August 25, 2021

Re: El Parador Multi-Family Development
201 Yale Blvd SE
Traffic Circulation Layout
Architect's Stamp 08-24-2021 (K15-D107)

Based upon the information provided in your submittal received 08-24-2021, the above referenced plan cannot be approved for Building Permit until the following comments are addressed:

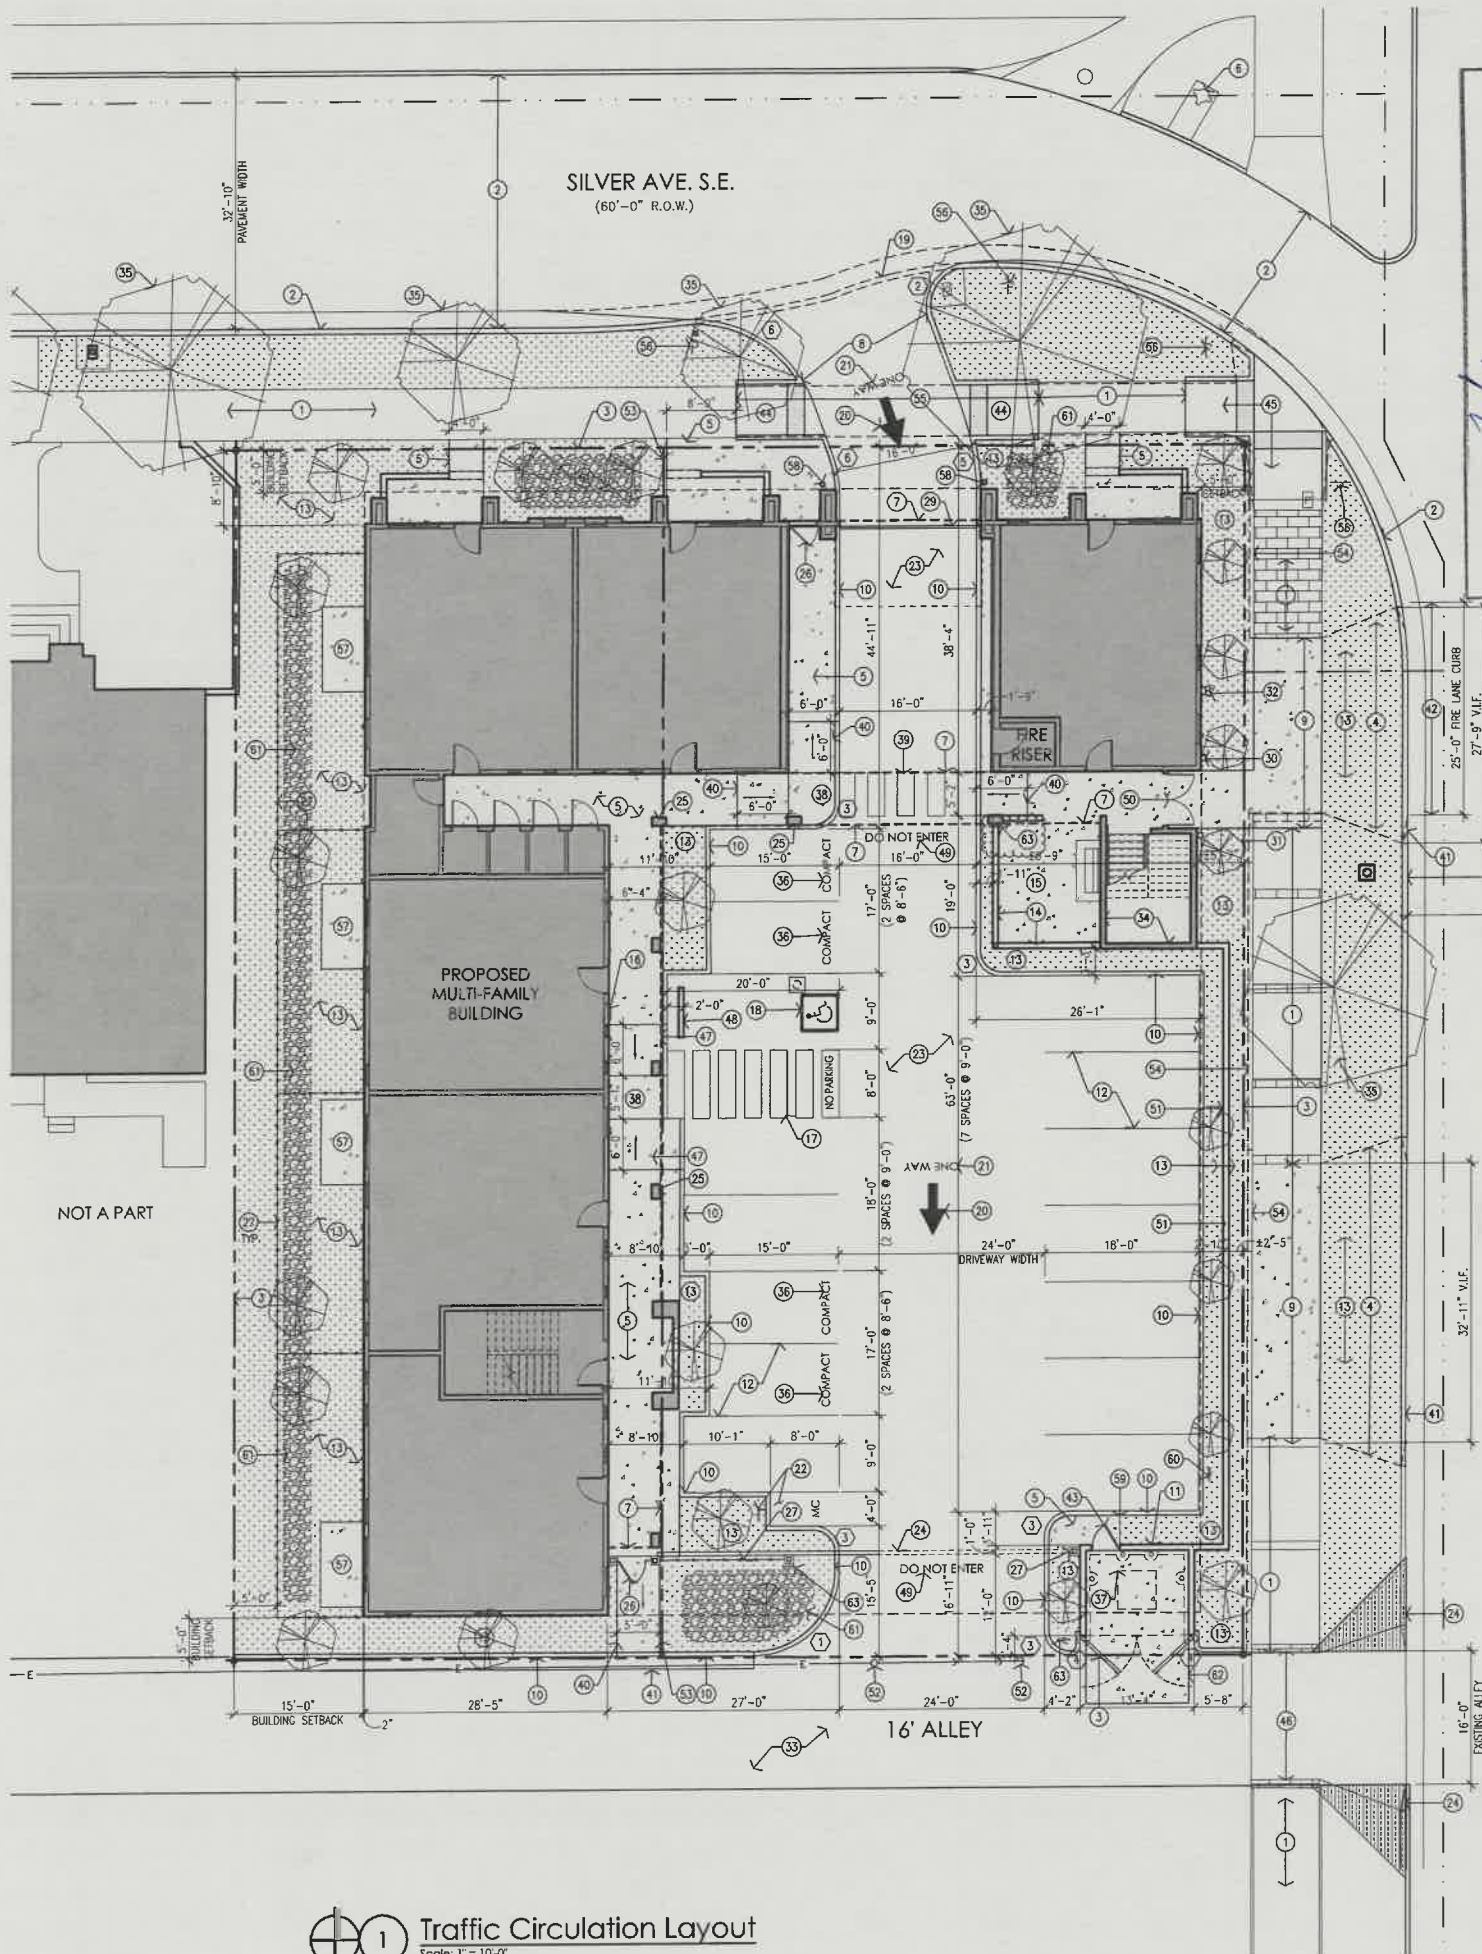
1. **Alley way/Yale proposed modified entrance:** You will need to provide construction notes/details for the entrance modification. Details will be needed for valley gutter transition from 6 ft valley gutter transitioning into a alley gutter. **The detail will need to be provided on TCL SITE PLAN.**

2. **A detail of the proposed, Private Entrance segment of Yale, 6 ft valley gutter transitioning on the existing drivepad gutter plan will need to be provided as part of the TCL site plan process.**

3. **FD approval will need to provided as part of the TCL submittal process (Request per email dated 08-04-2021).**
4. **Alley pavement design. The pavement design need to be provided on the proposed TCL Site Plan project.**

5. **Provide a copy of refuse approval.**
6. **All one-way drives shall have "One Way" and "Do Not Enter" signage. Please show/provide detail detail and location of posted signs.**
